**State Significant Development Application SSD-21208499**  
**Glanmire Solar Farm**  
**Site: 4823 Great Western Highway, Glanmire (Lot 141 in DP 1144786)**

I make this submission in objection to Elgin Energy Pty Ltd's (**Elgin Energy**) State Significant Development Application SSD-21208499 (**Application**) to develop a 60 MW solar farm with a 60 MW / 60 MWh battery energy storage system and associated infrastructure (**Development**).

Glanmire Solar Farm
Indicative Site Layout Plan

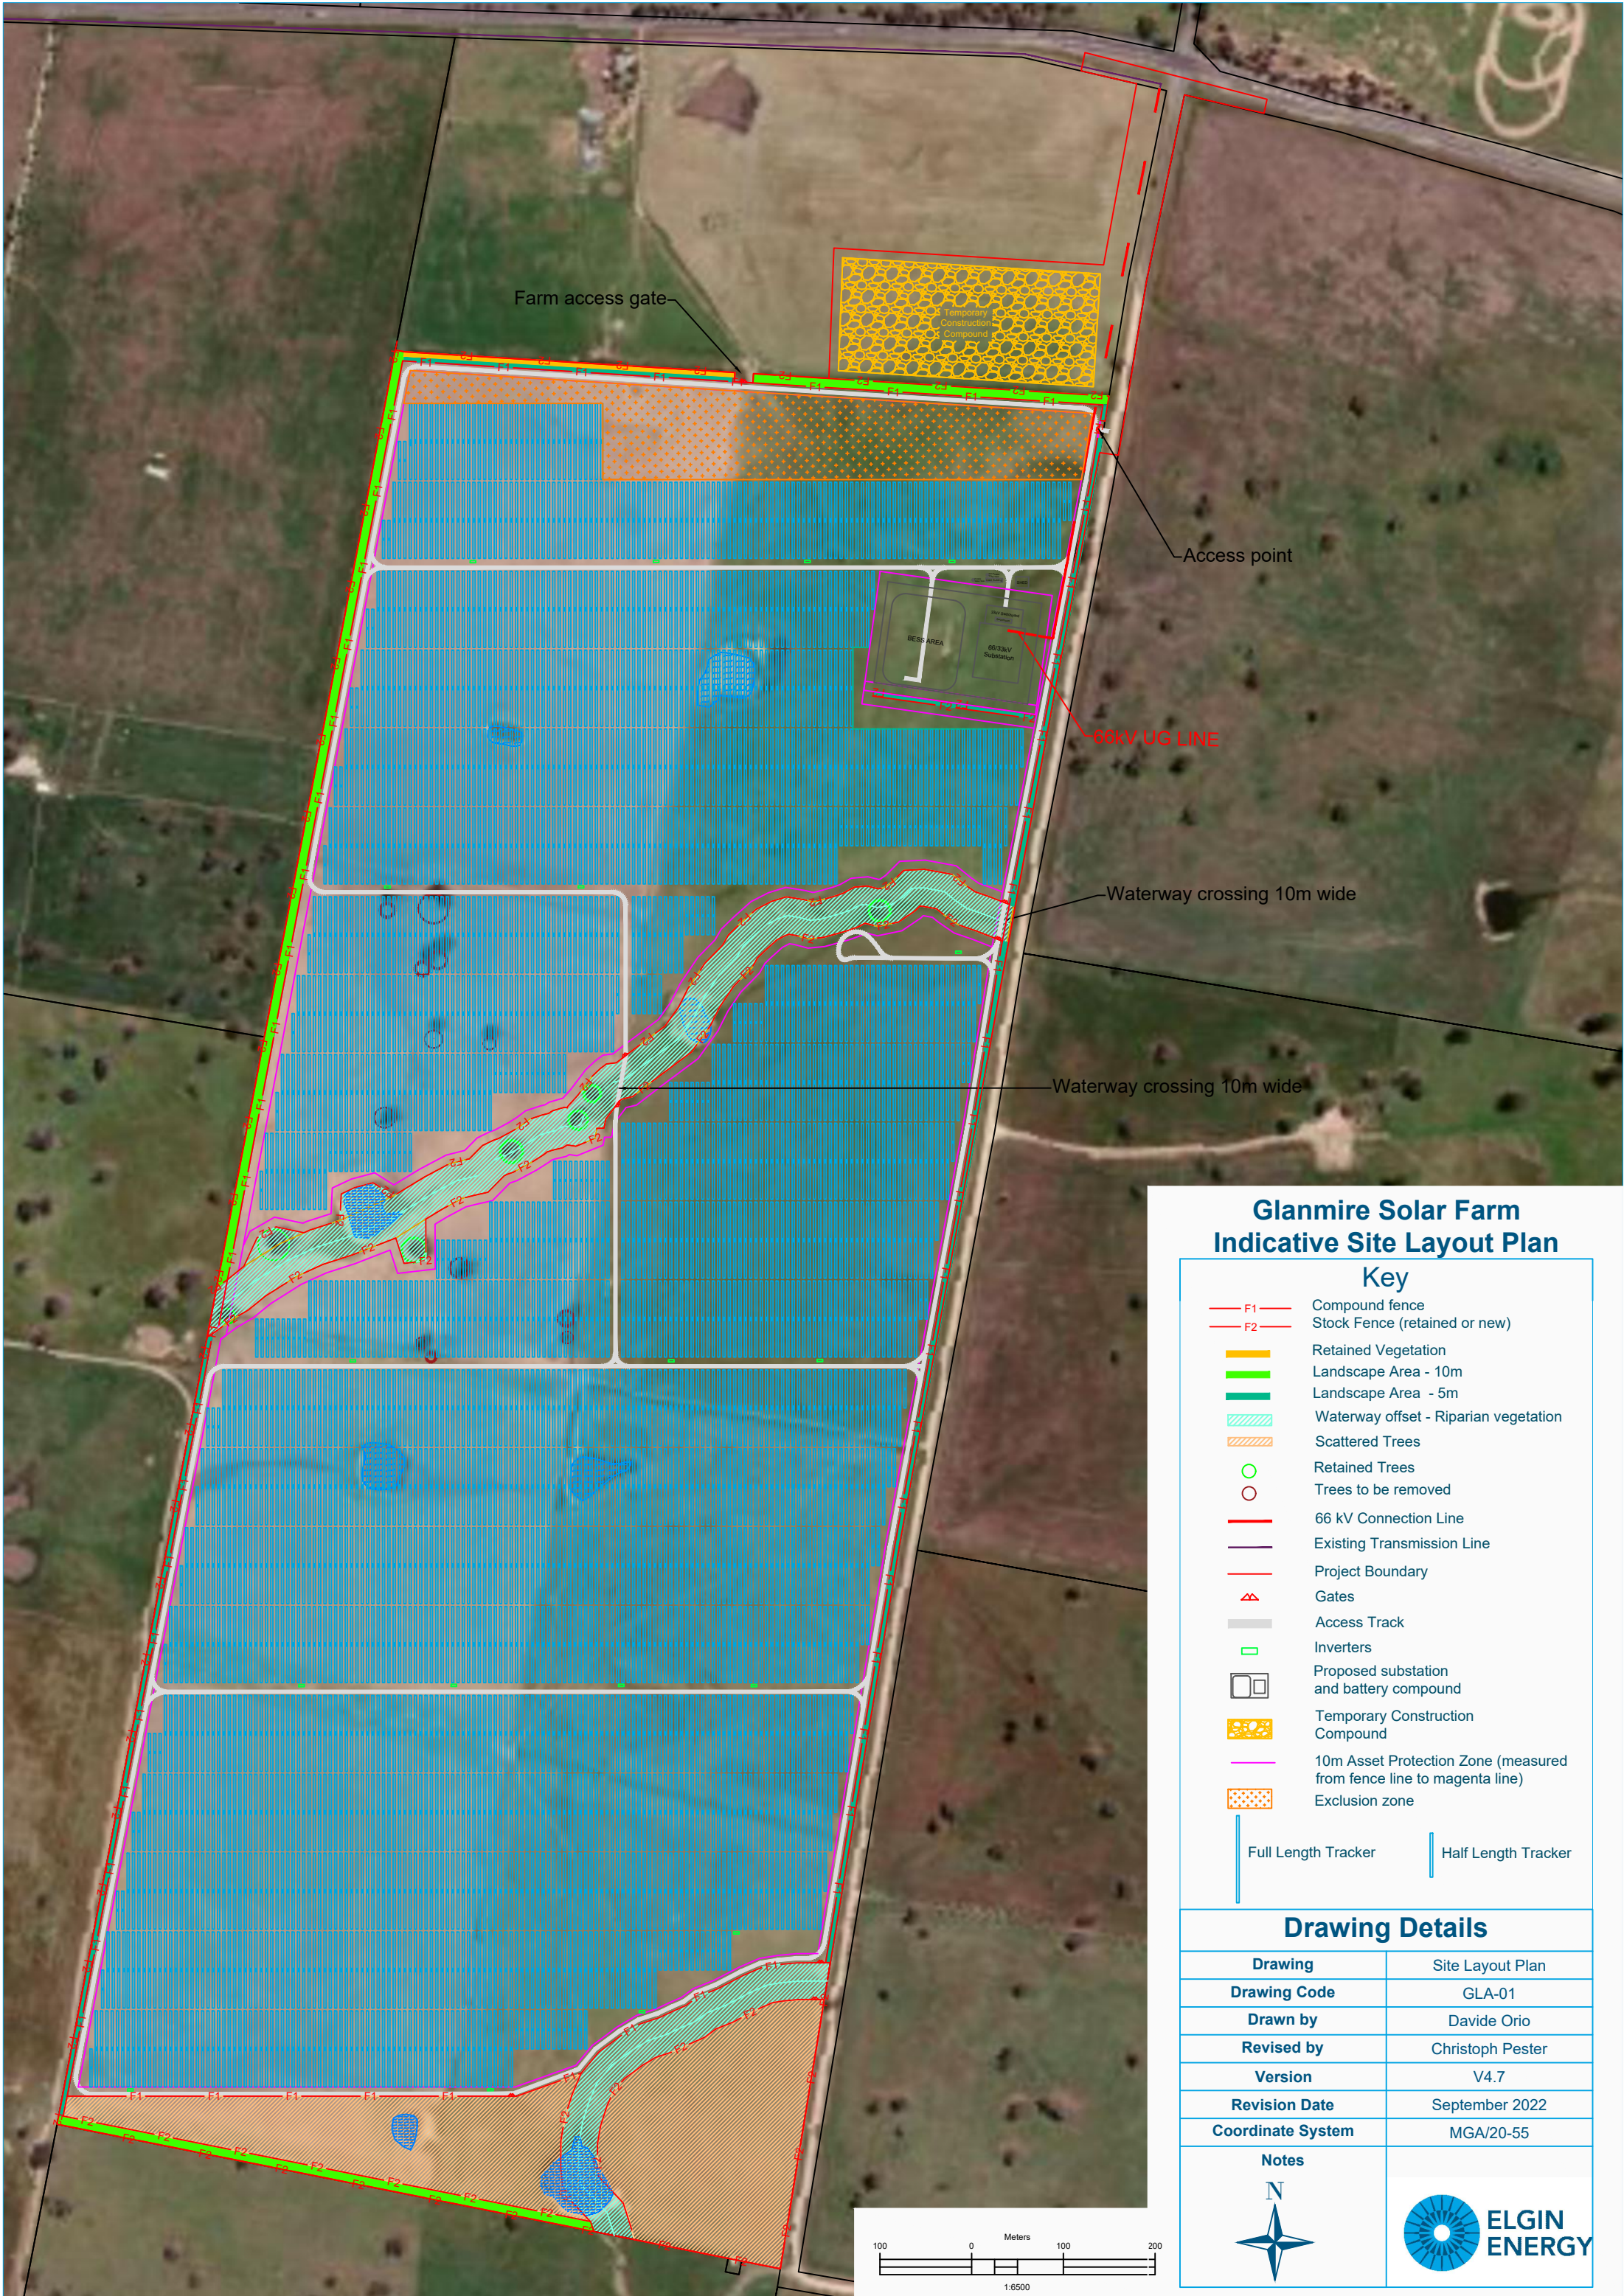
The Application proposes a 10m Asset Protection Zone, which is inadequate to mitigate against the risk of fire. It also fails to provide an appropriate setback between the Development and my Land.

It is my submission that, if the Development is approved, a setback of no less than 30m should be imposed between the Development and my Land, which will be used for cropping activities.

The need for a 30m setback where a solar farm is located adjacent to a cropping activity is anticipated by the Department of Planning and Environment's *Large-Scale Solar Energy Guideline* (August 2022), which states (pg35) as follows:

*Where a solar energy project is located adjacent to a horticultural or cropping activity, the solar array should be setback from the property boundary by at least 30m to mitigate any heat island effect.*
